From: Robert Steventon [REDACTED]
Sent: 02 October 2019 16:38
To: Laura Gibbons <Laura.Gibbons@arun.gov.uk>
Cc: Paul Cann <Paul.Cann@arun.gov.uk>; Andrew Wood <Andrew.Wood@arun.gov.uk>;
[REDACTED] Wayne Stutchbury' [REDACTED] Kevin Lang'
Subject: RE: Planning Consultation on A/113/19/DOC - Angmering site

Engineers Comments Regarding Condition 9- surface water drainage design

Site Address: Crete Nursery Dappers Lane Angmering BN16 4EN

CRETE NURSERY, DAPPERS LANE, ANGMERING, BN16 4EN

DRAWN	RS	CHECKED	KBL	APPROVED	KBL
DATE	Jul-19	DATE	Jul-19	DATE	Jul-19
SCALE	1:200	PRJ No.	191183	SIZE	REV
DWG No.	191183/500/01				
				A1	D

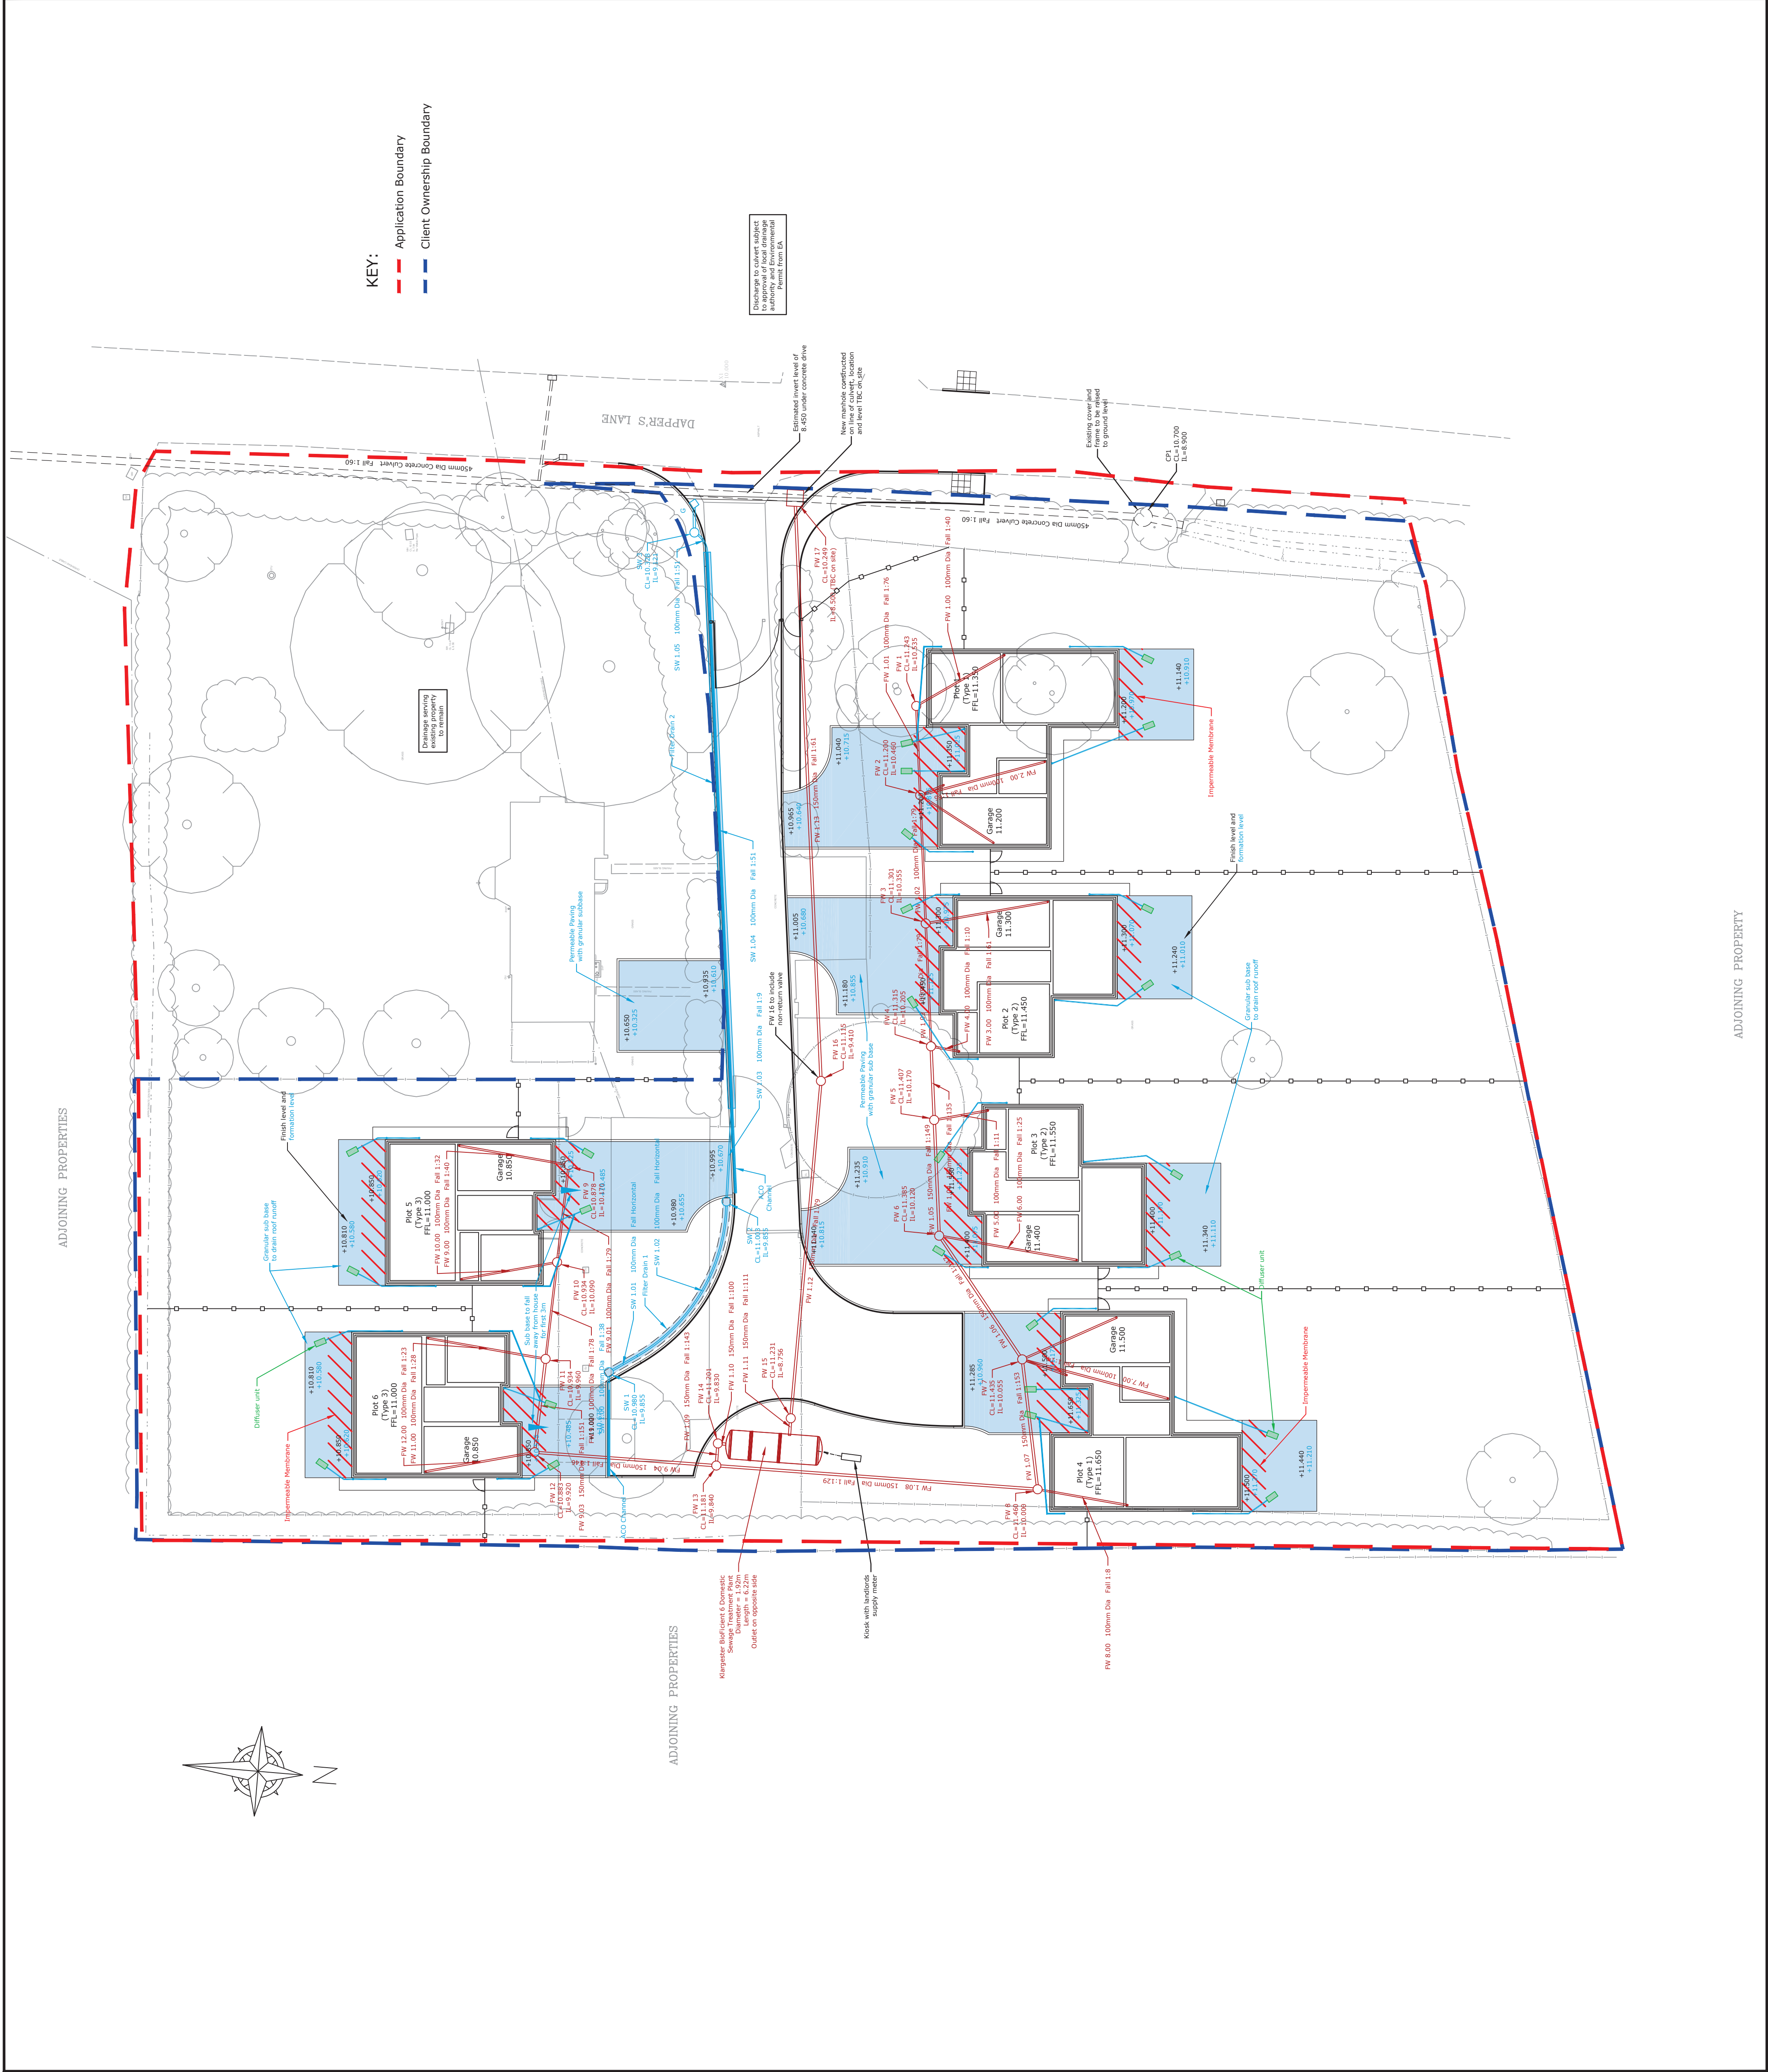
11. Please provide invert levels and cover levels of all inspection chambers, manholes, filter drains, etc. Please also ensure that finish and formation level of permeable paving is clearly provided on plan. Please refer to drawing 191183/500/01. I will review further once GW and infiltration testing result acceptability has been agreed.

11. Please provide invert levels and cover levels of all inspection chambers, manholes, filter drains, etc. Please also ensure that finish and formation level of permeable paving is clearly provided on plan.

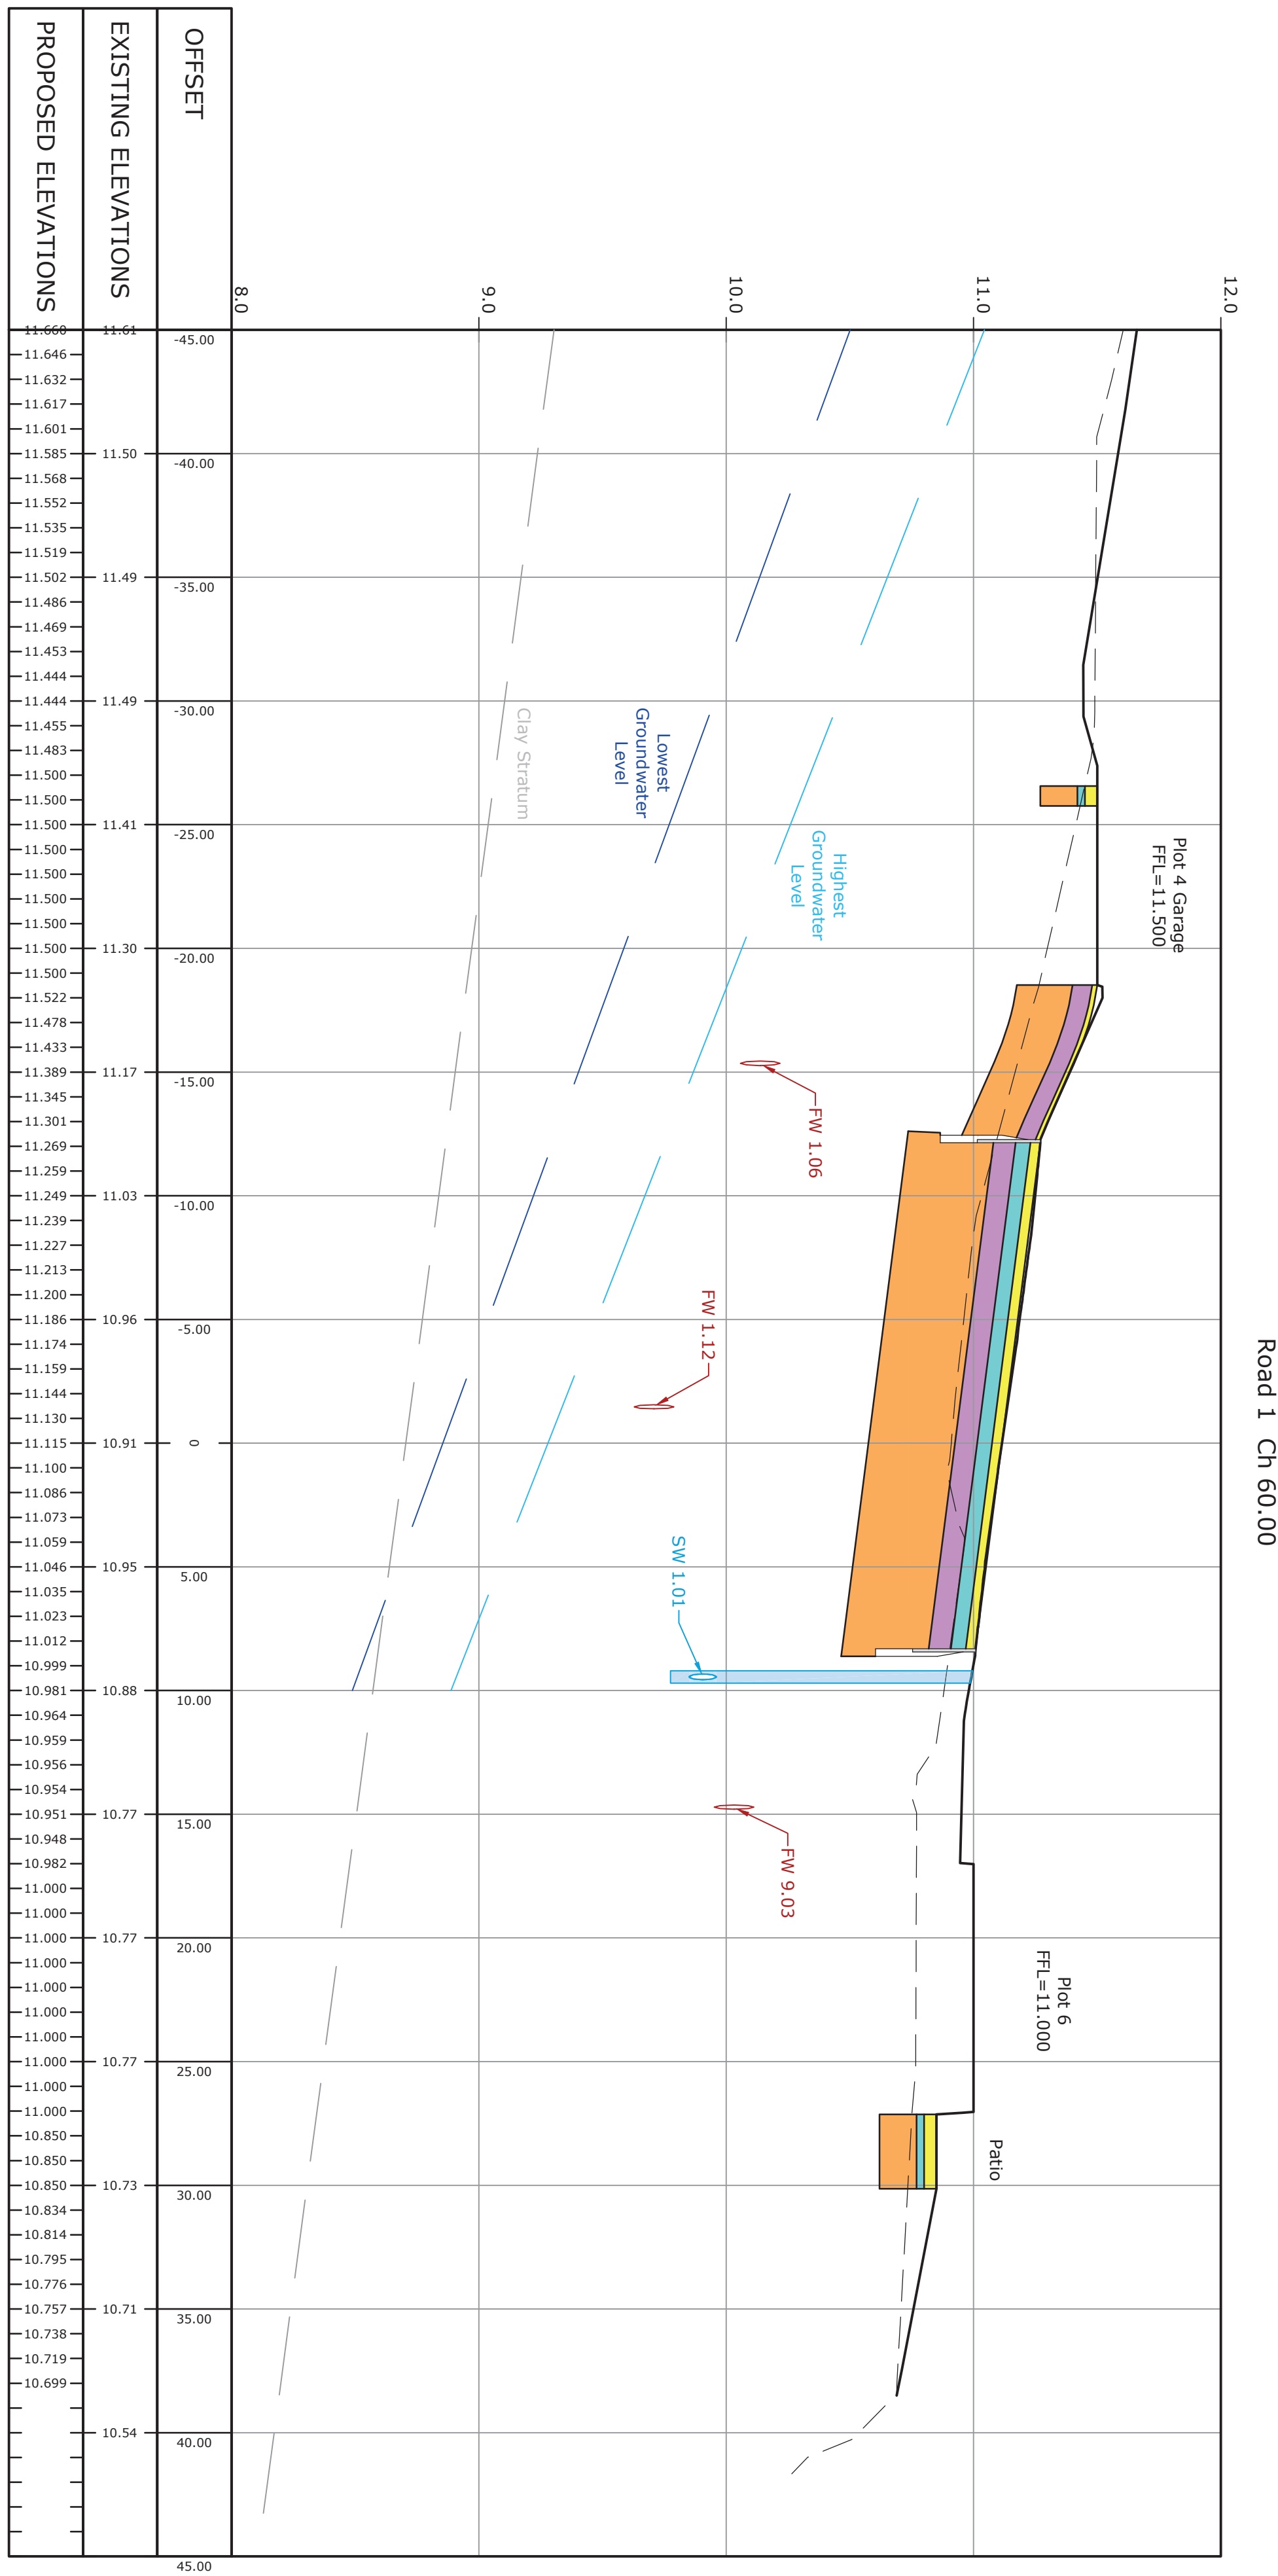
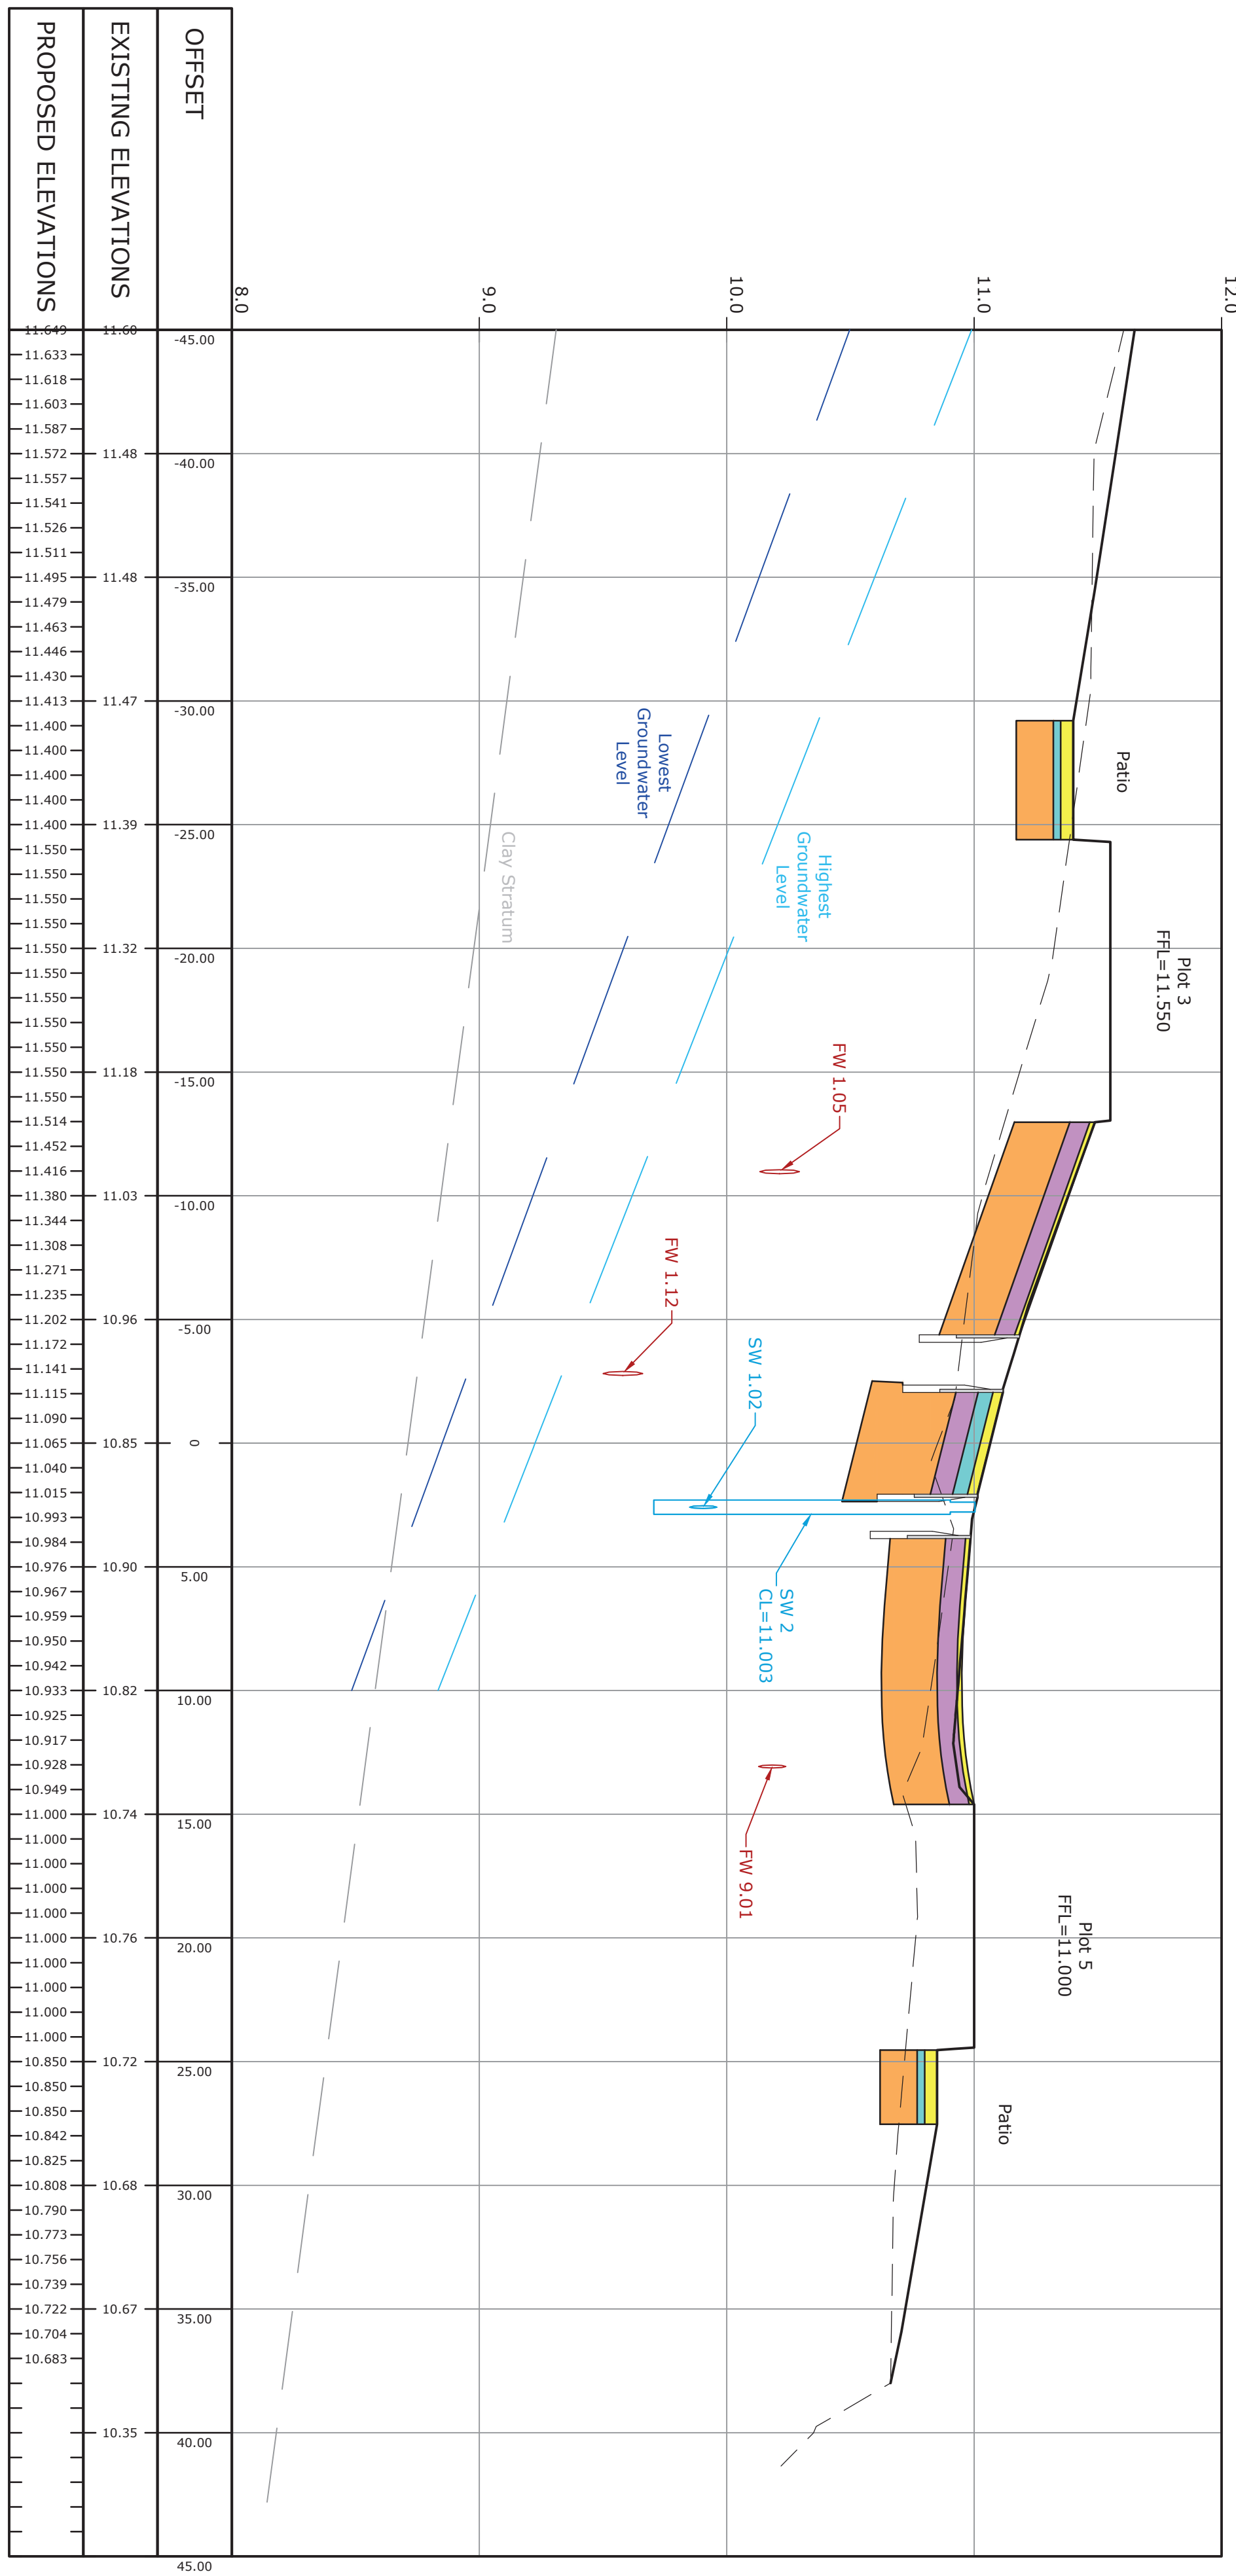
5. From looking at cross sections it also appears that the filter drain will be on a slope, please ensure this is accurately depicted within calculations.

5. From looking at cross sections it also appears that the filter drain will be on a slope, please ensure this is accurately depicted within calculations.
